WEST SUSSEX COUNTY COUNCIL CONSULTATION

TO:	Arun District Council FAO: Anita Gardner
FROM:	WSCC - Highways Authority
DATE:	25 July 2019
LOCATION:	St. Marys Close, Hurst Road, Rustington, BN16 3AP
SUBJECT:	R/130/19/PL Application for variation of a condition following grant of planning permission R/190/18/PL relating to condition no.2 - amended access points.
DATE OF SITE VISIT:	N/A
RECOMMENDATION:	Advice
S106 CONTRIBUTION TOTAL:	N/A

Drg No: 151117 SL-02

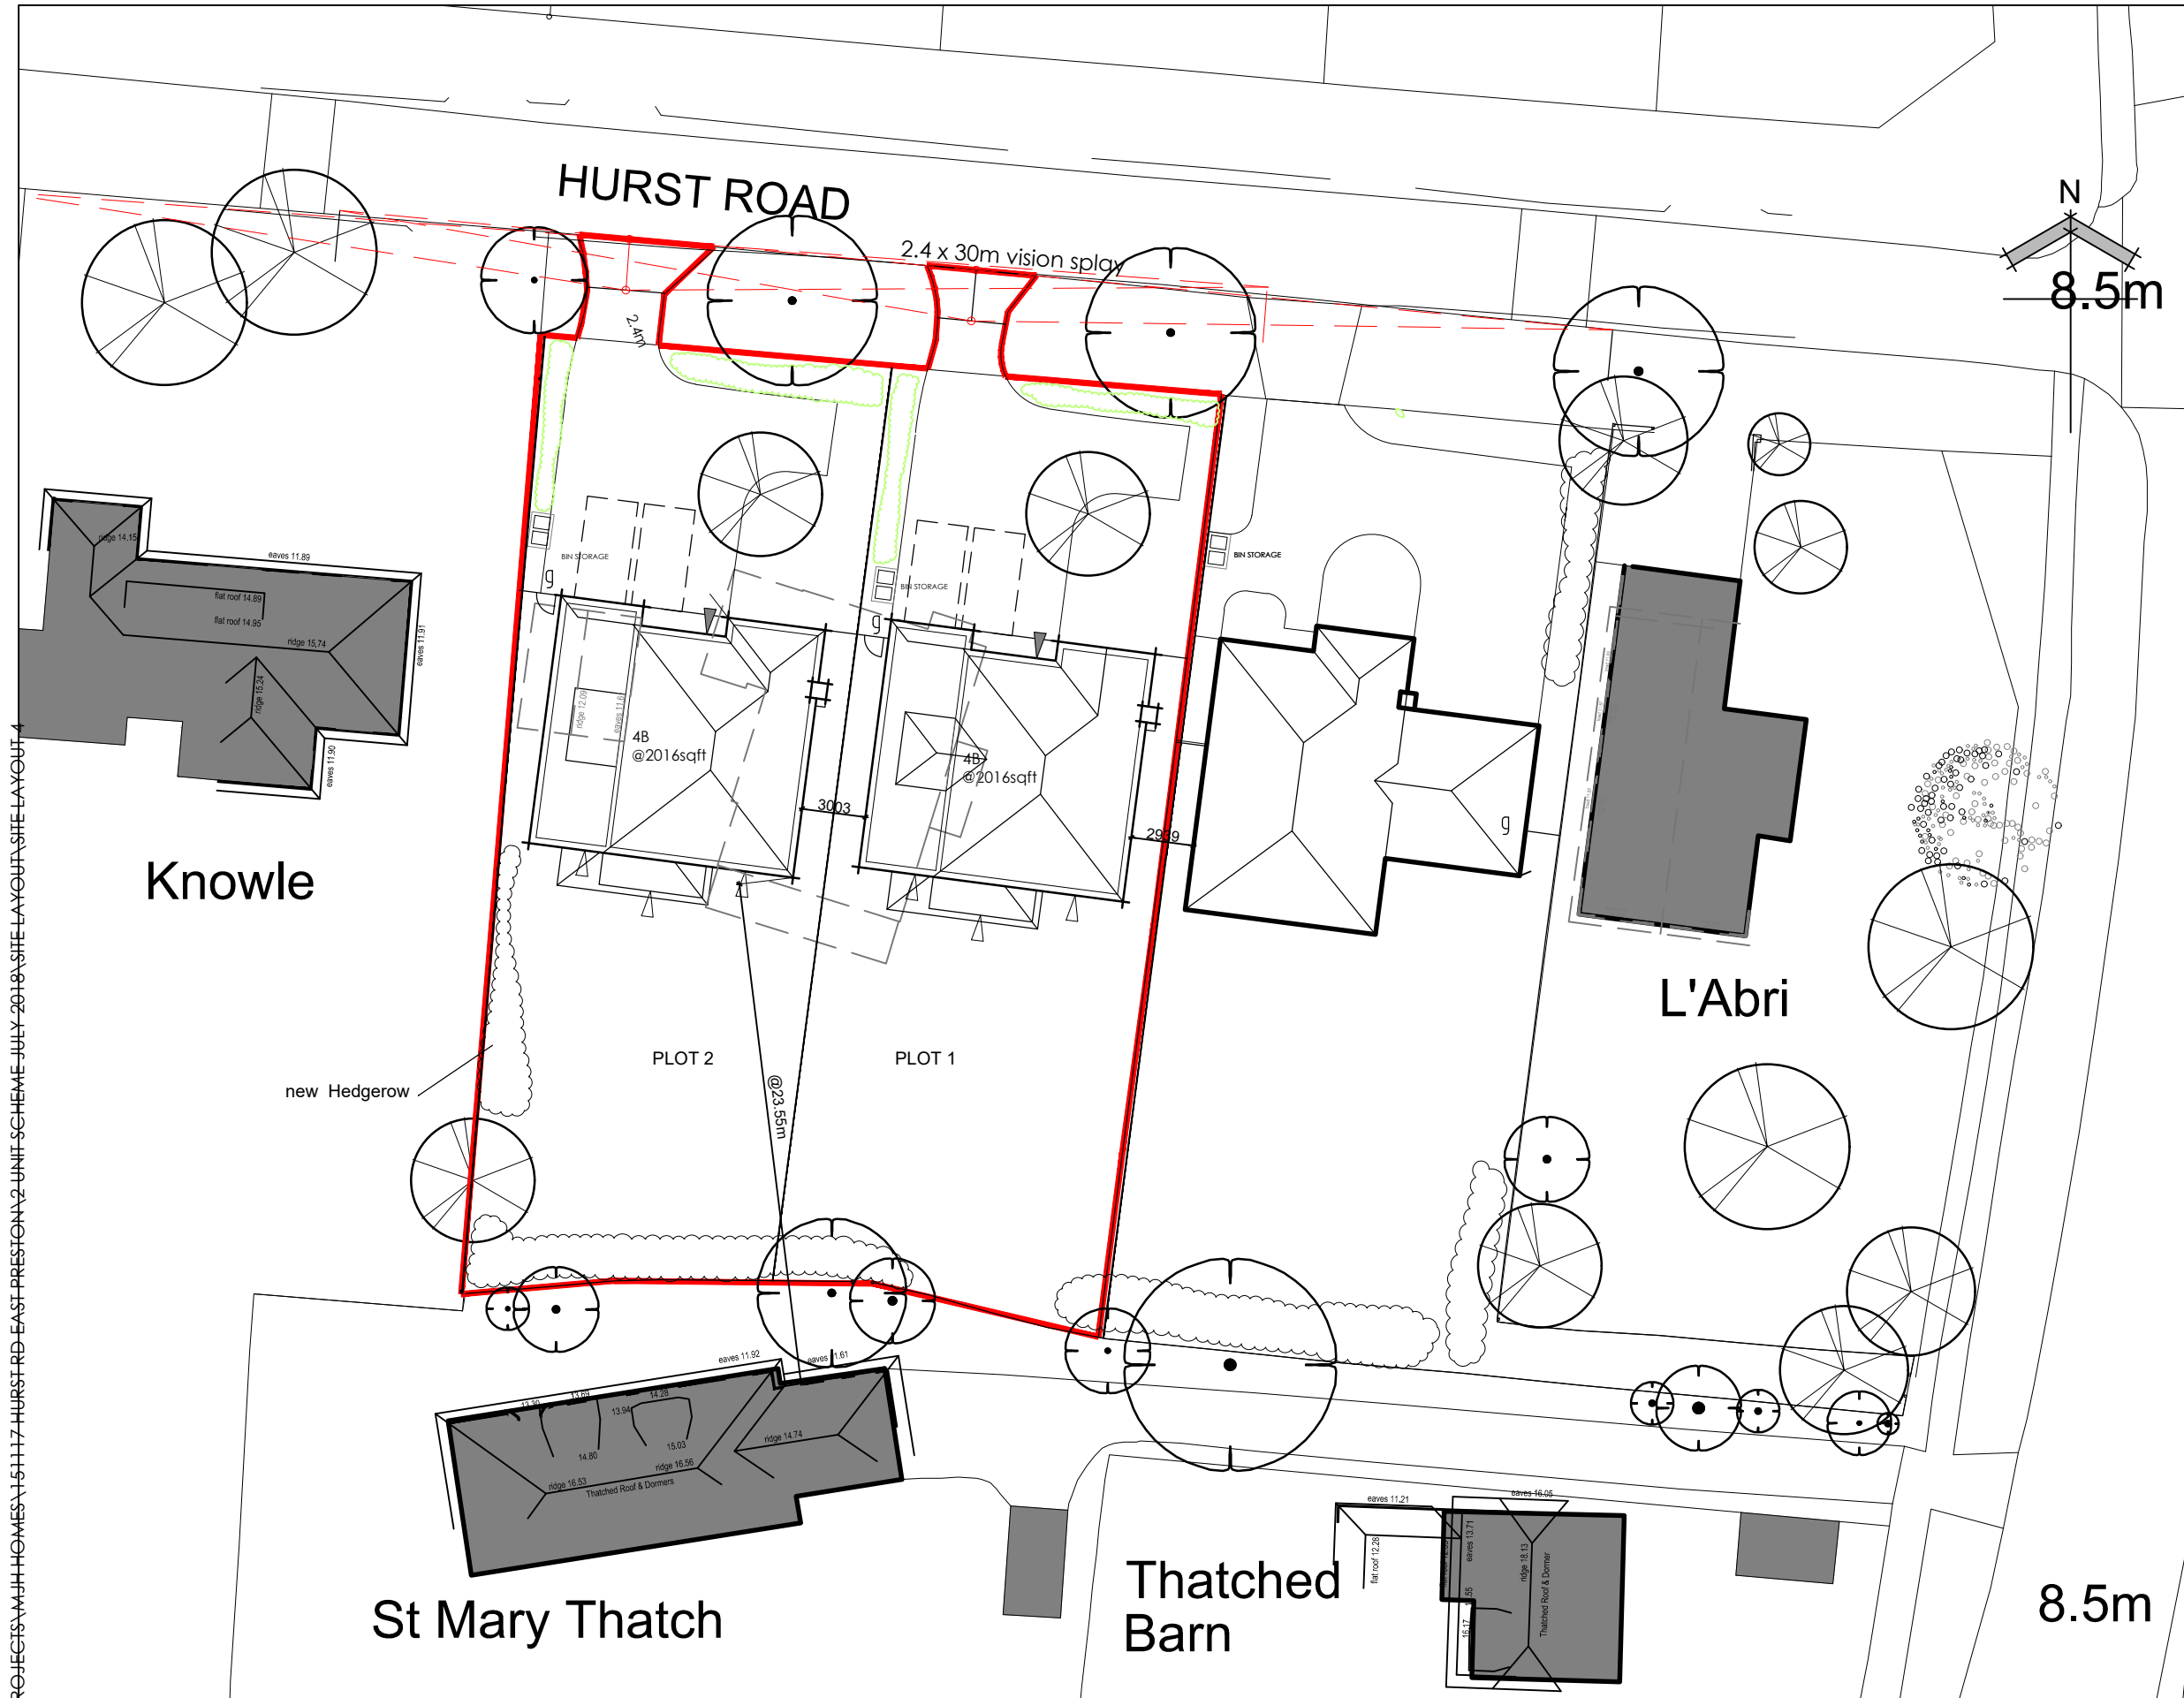
The original access on Hurst Road was to be shared by both properties. However, each property will now have a separate access point off of Hurst Road. This proposal does not affect parking provision and on-site turning will still be achievable. The applicant should ensure they have approval from the proprietor of Hurst Road to conduct the works for the proposed accesses.
